## Fire Marshal Division

**Re: Mary Lane (Mary's Auction House)**  
**2281 Ray Road**  
**Spring Lake, NC 28390**

**Application Number BCOM1902-0008**

Mary's Auction Service
2281 Ray Rd
Spring Lake NC 28390
910-260-1394
Fridays 7pm-9pm

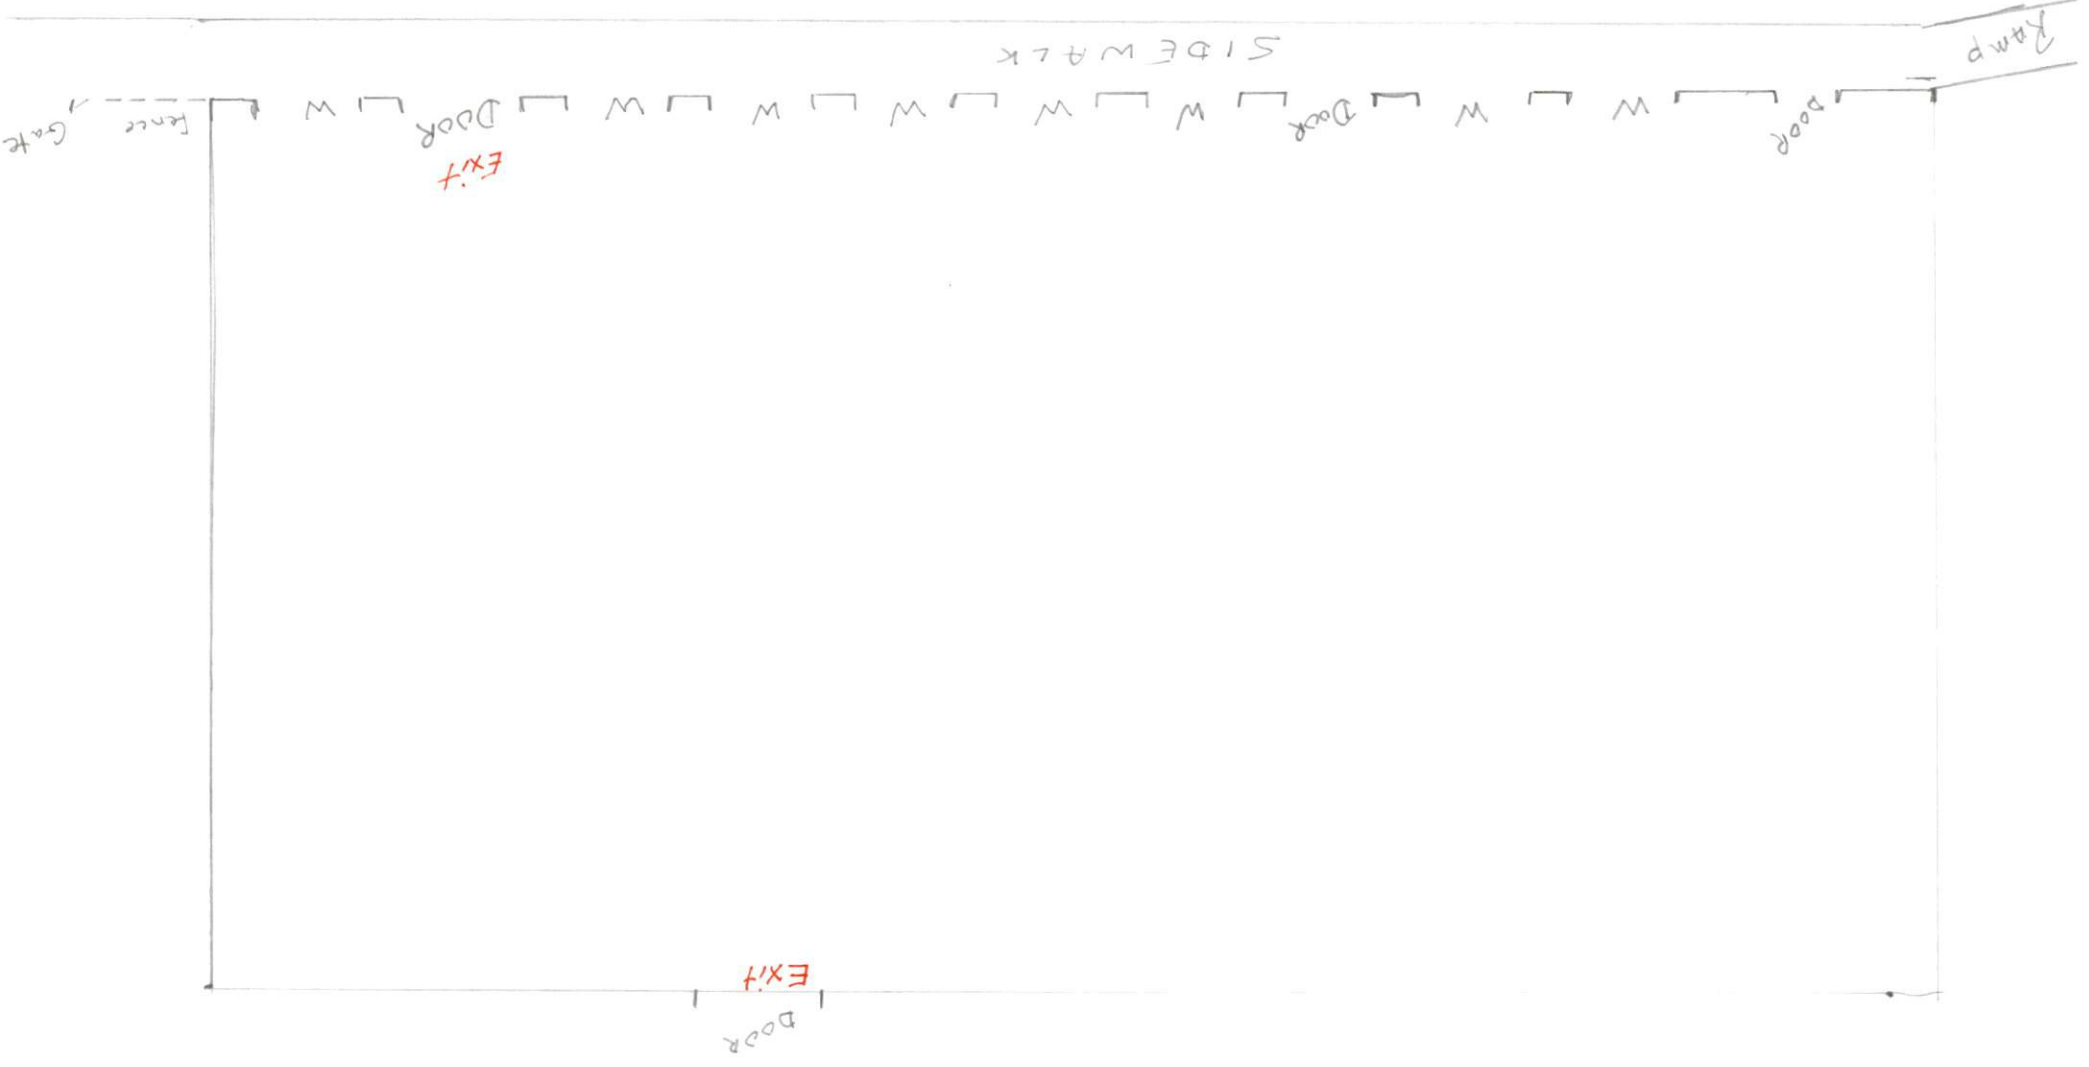
- **1008.1.10 Panic Hardware**
  - UL 305 listed panic hardware is required on exit doors serving a room/space with an occupant load >49, also indicated on Building code summary. Panic hardware is not included on door schedule sheet B8 of Drawings.
